**From:** [Redacted]  
**Sent:** 22 October 2013 12:25  
**To:** Planning  
**Subject:** Welwyn Hatfield Council Online Planning - Comment

Application Number: N6/2013/1938/MA  
Name: Jennifer M McCann  
Address: 51 Valley Road  
Welwyn Garden City  
Herts AL8 7DH

Title Proposed Sections

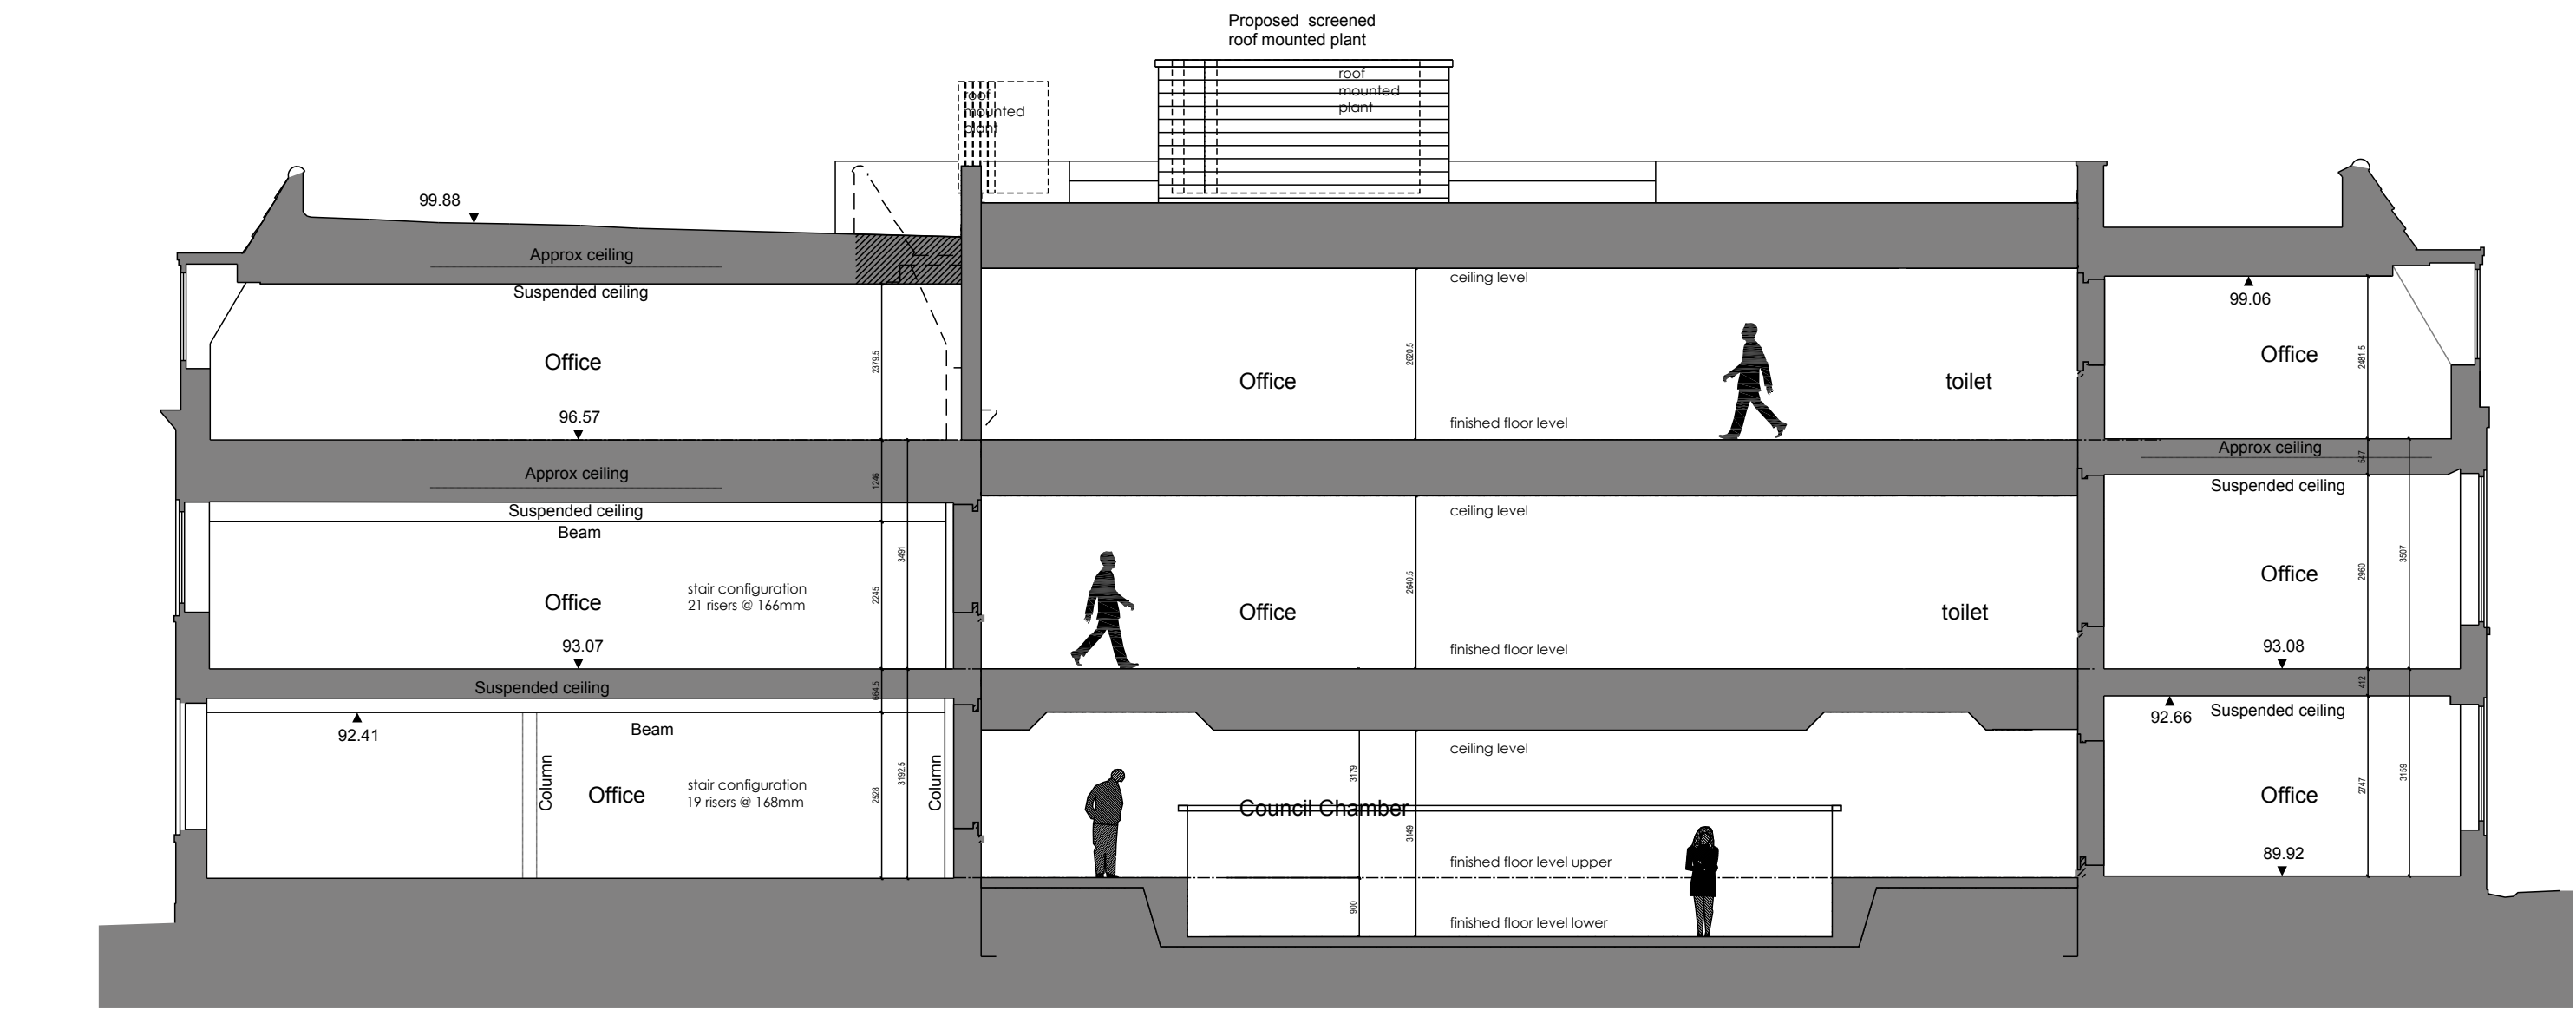
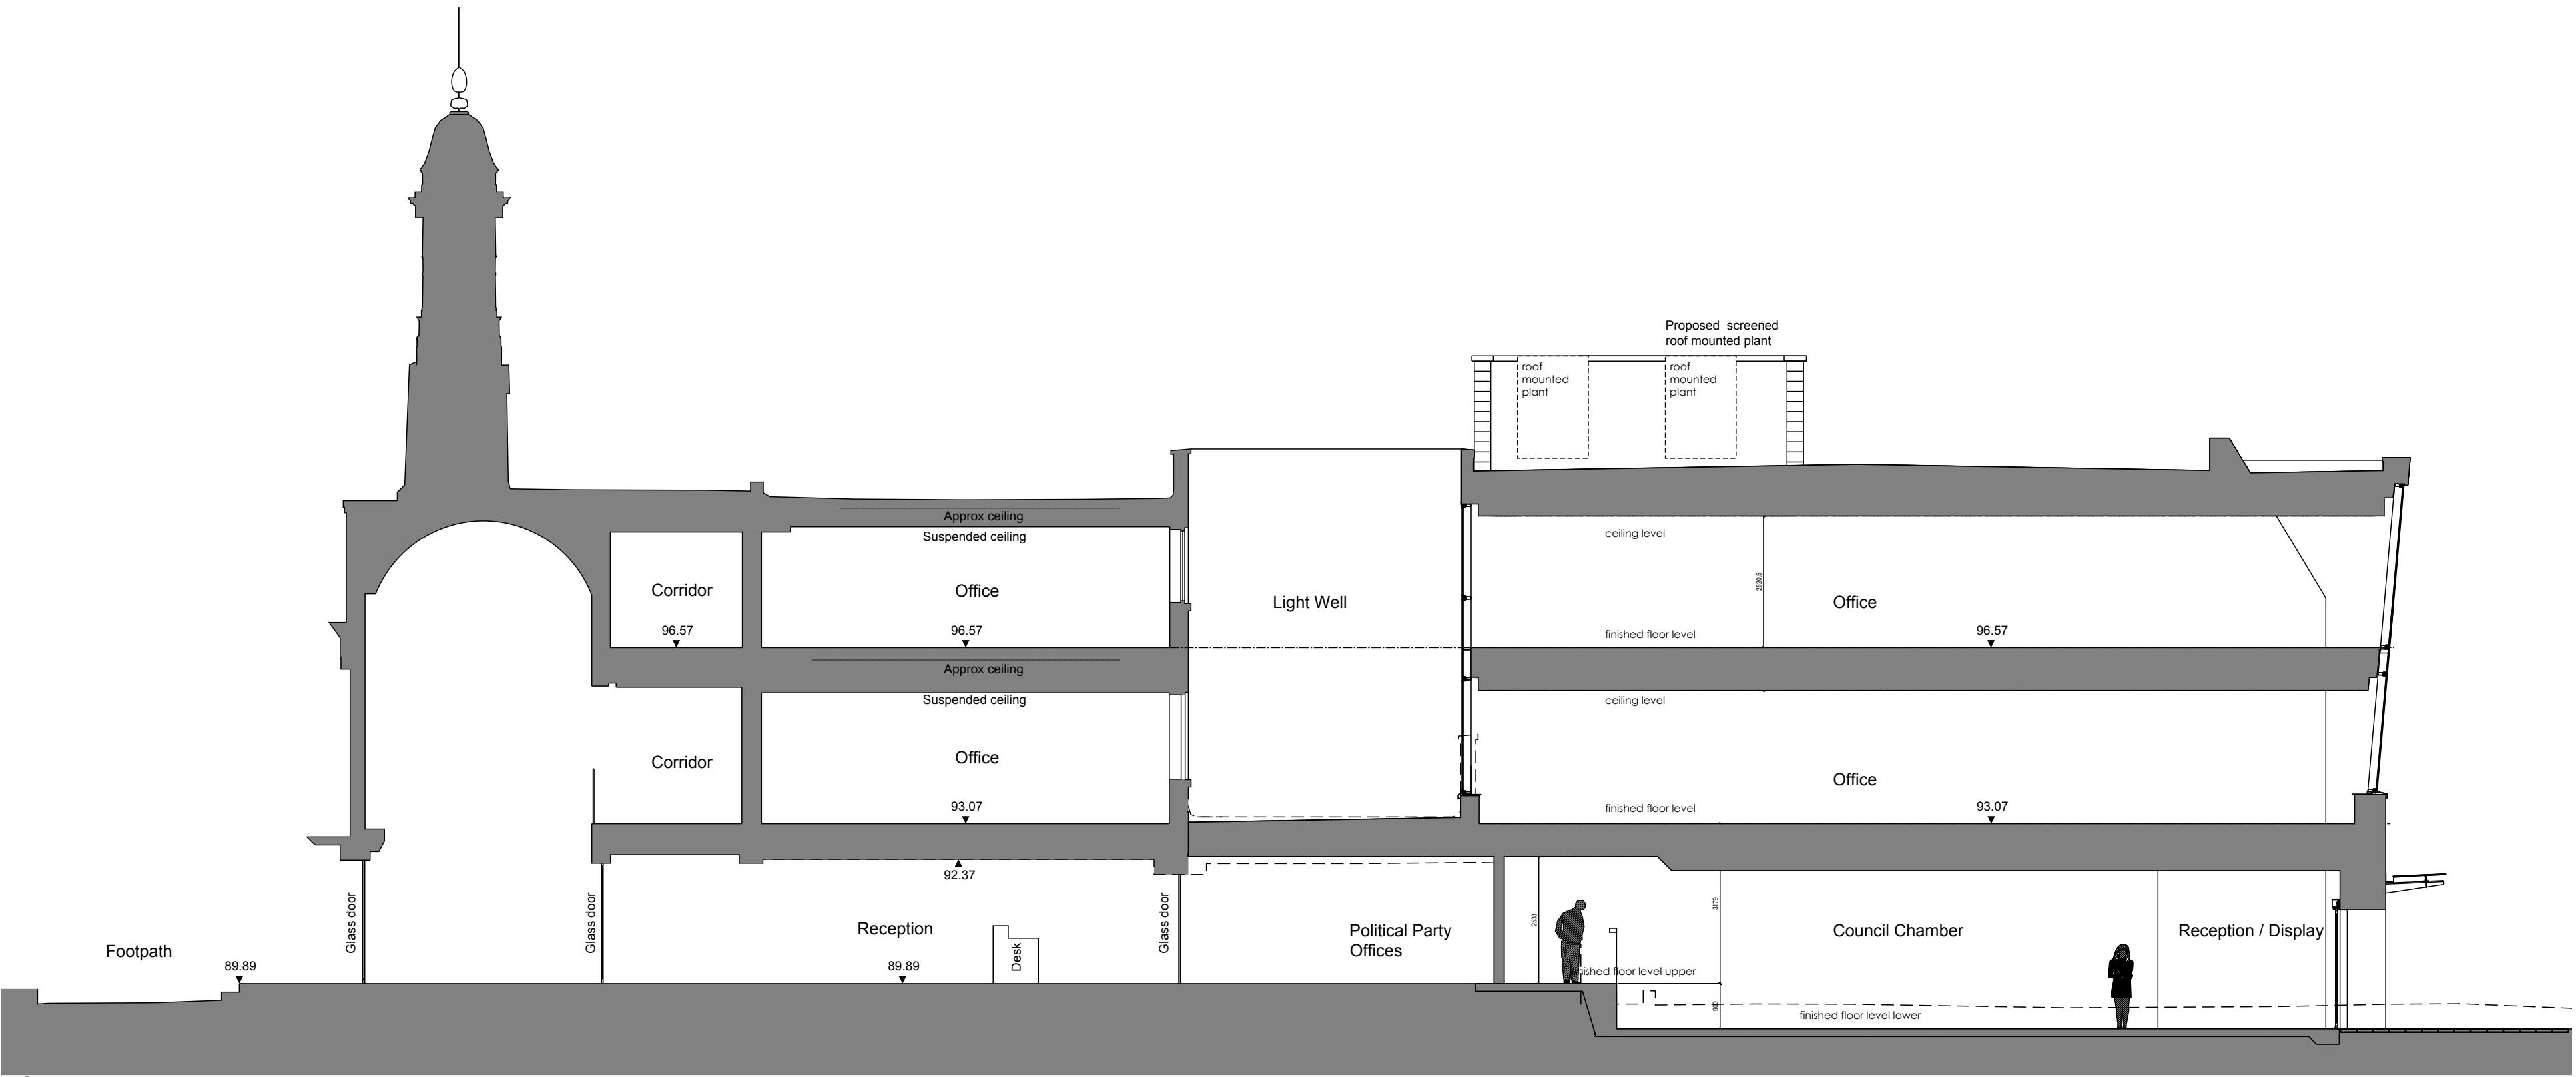
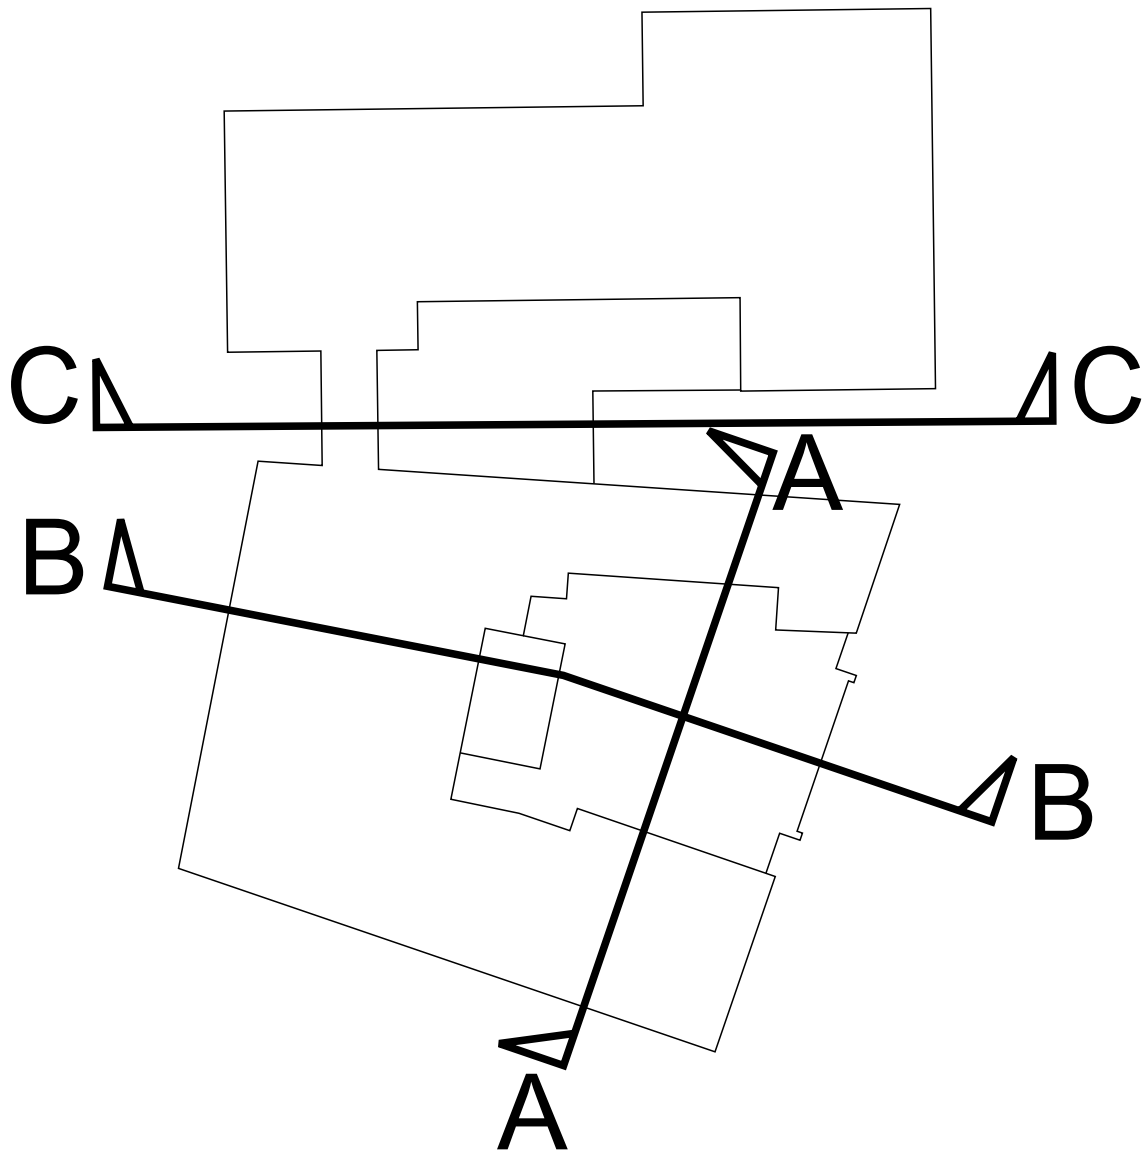
Comment: The projections shown on the drawings for this planning application are wholly inappropriate, given the Conservation Area and EMS constraints applicable. It is an insult to the existing building, giving greater prominence to the rear rather than the original entry, uses zinc and glass, rather than brick and is overbearing. Peel Court is an excellent example of what is achievable - just take a look across the road.
